STAFF REPORT

Events at Brickhouse Nursery Conditional Use Permit (CU-22-00004)

TO: Kittitas County Hearing Examiner
FROM: Jeremiah Cromie, Staff Planner
RE: Events at Brickhouse Nursery Conditional Use Permit (CU-22-00004)
DATE: March 23, 2023 (Hearing Date)

**SITE PLAN 11x17
EVENT USE**

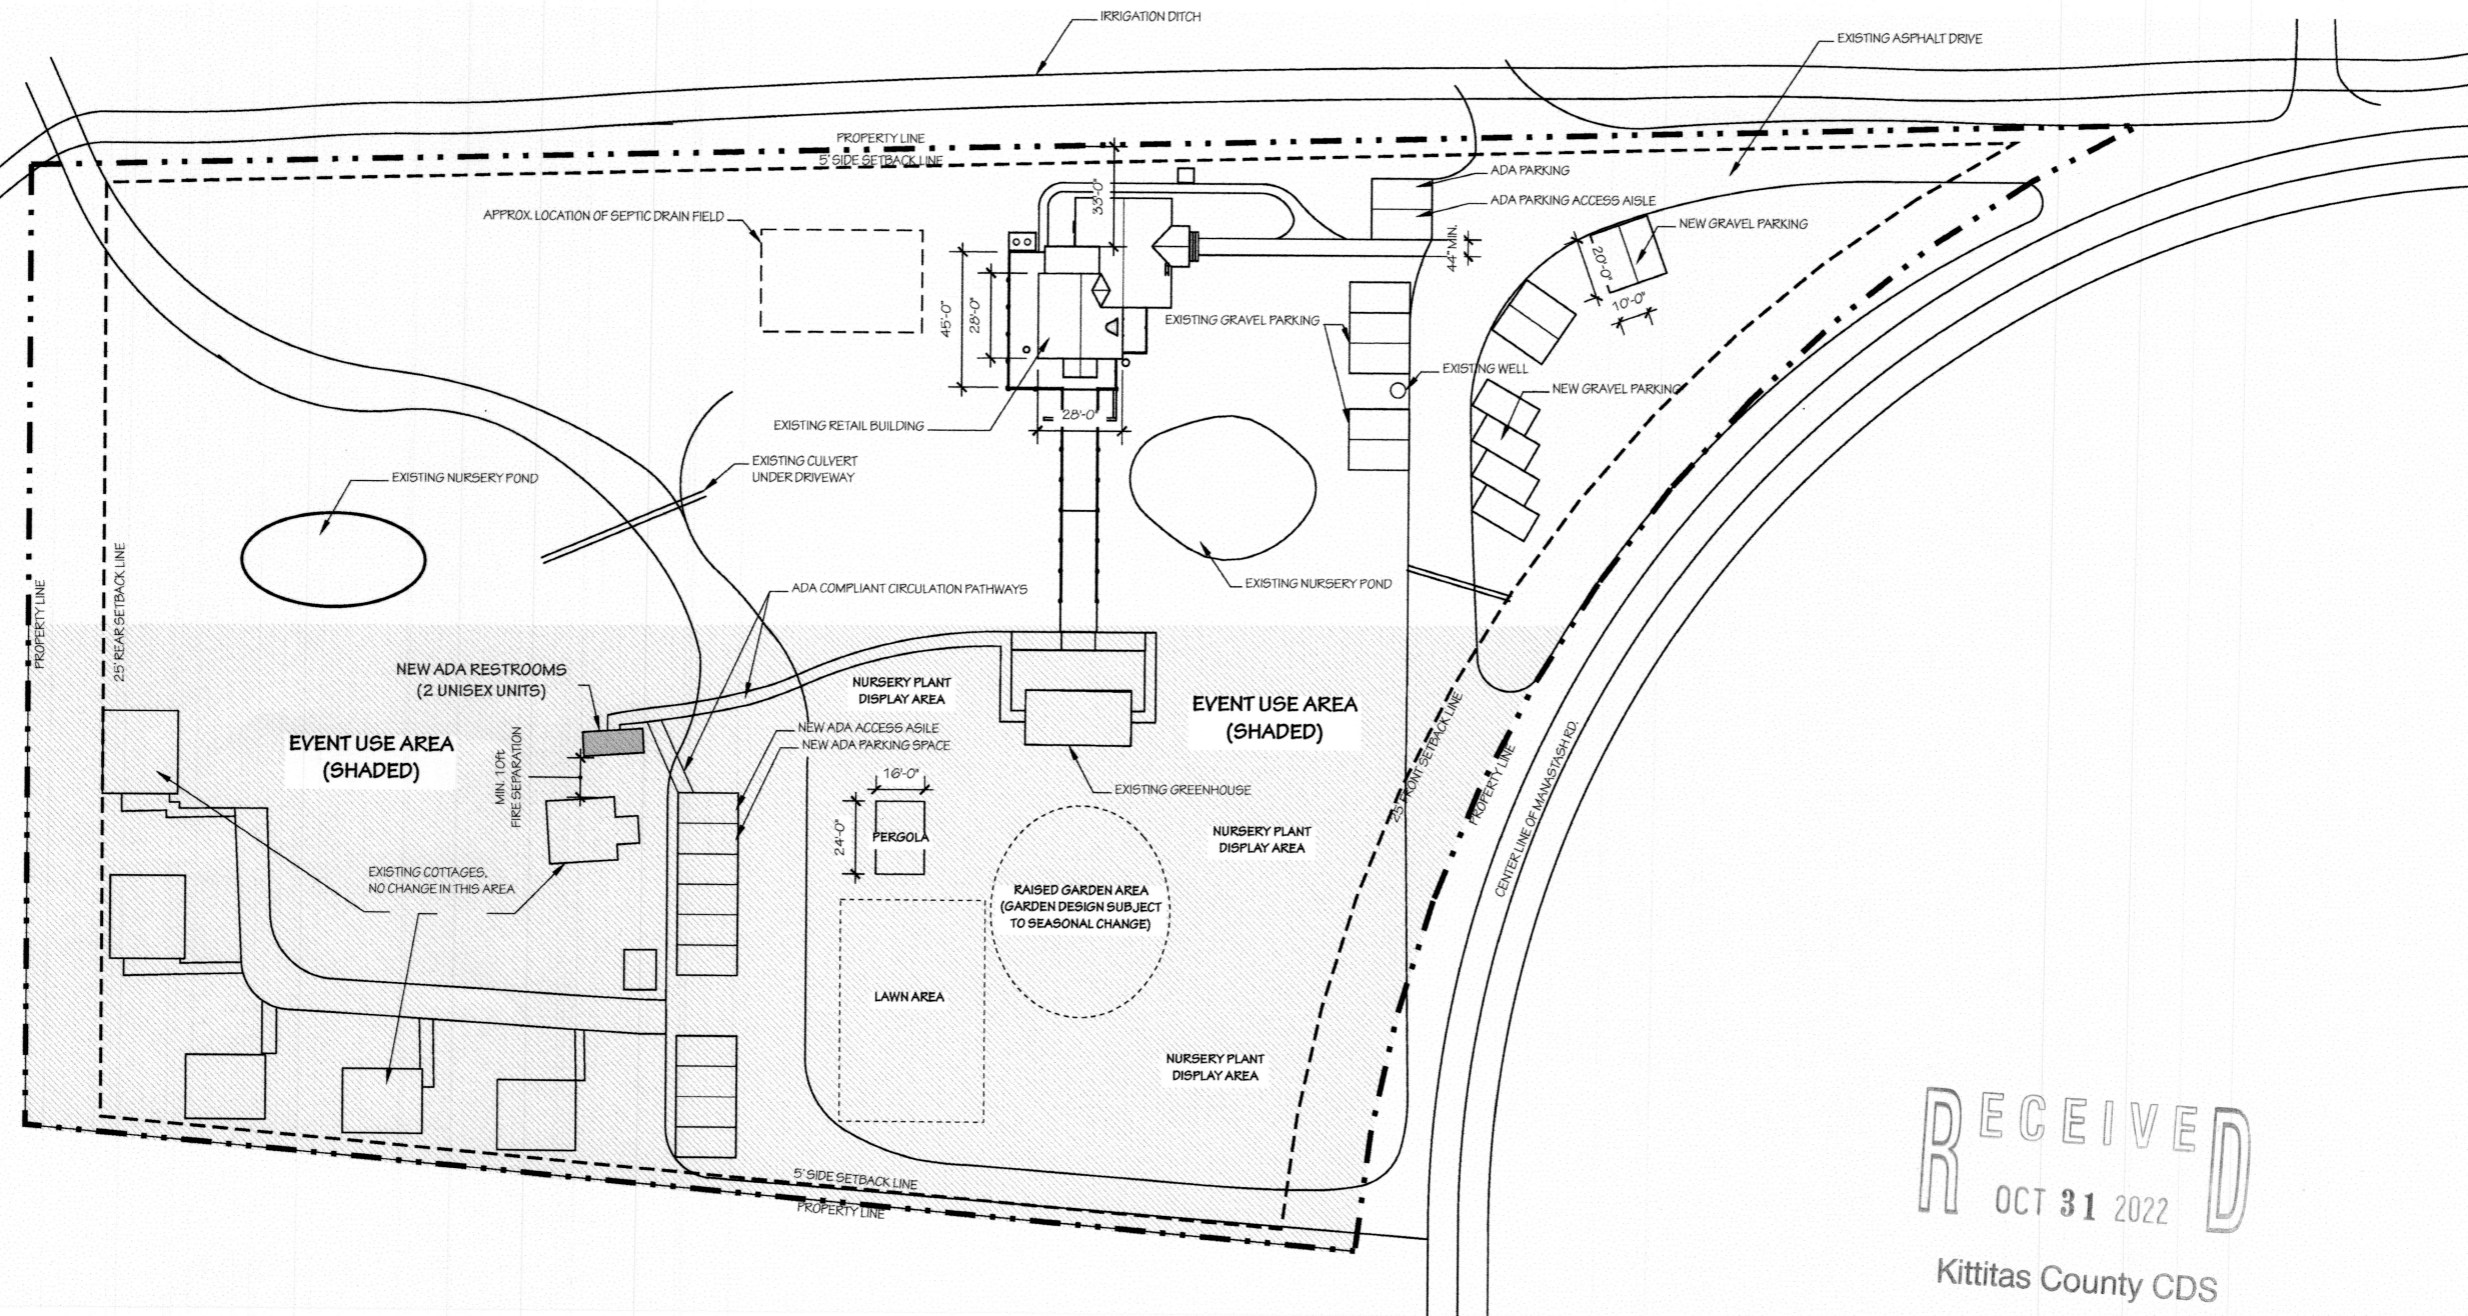
2. Events shall be limited to the event use area identified on the site plan and the retail nursery shall be closed during events unless this conditional use permit is amended.

11. There shall be no parking on any Right-Of-Way or Manastash Road at any time.
12. There are three access points to the parcel. The owner/proponent must close the middle access during events due to the proximity of entrance locations and sight distance.

Verify there is no more than 1:20 slope for the Accessible path from Accessible Parking to the building(s) and all facilities entrances and amenities. Please show path and state the maximum allowed slope on the drawings.

Please show this accessibility on an updated site plan and building permits for approval. Accessibility requirements must be approved by Kittitas County Community Development Services prior to any events taking place.
